Application for a non-material amendment following a grant of planning permission.

Demolition of chimney stack, replacement of slate roof, removal of dormer window and installation of velux window, and other associated works.

20/0970/HH

ADDITION OF TWO VELUX STYLE CONSERVATION GRADE ROOF WINDOWS TO THE KITCHEN ROOF

TY CAPEL, ABERCEGIR
DRAWING 12, NORTH ELEVATION (REAR)
(PROPOSED, AMENDED 22/2131/NMA)
SCALE 1:50

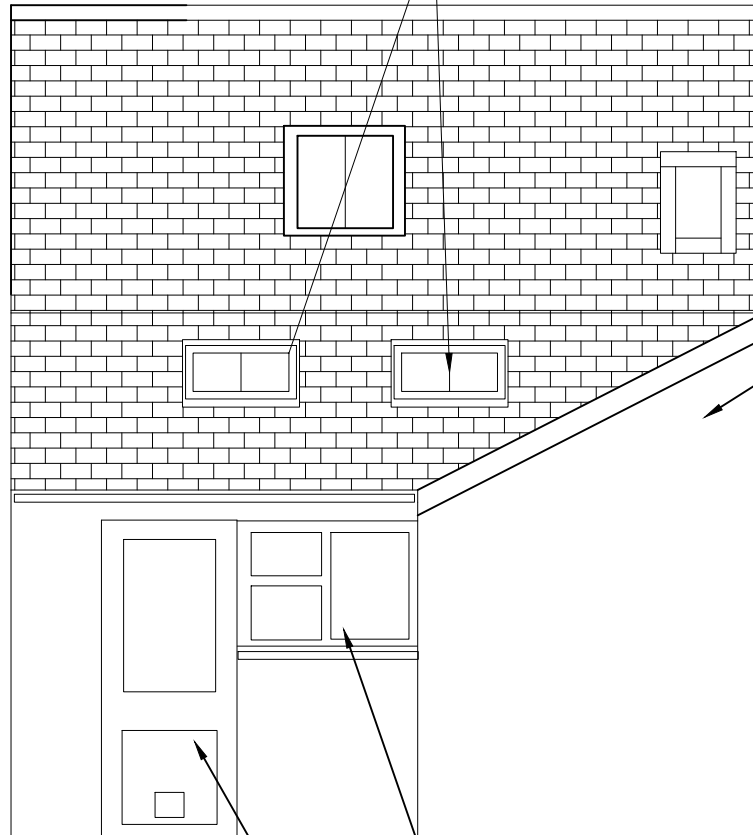
Ty Capel DWG 12 PLAN VIEW (AMENDED) 28/11/22, Ty Capel DWG 14 NORTH ELEVATION (AMENDED) 28/11/22
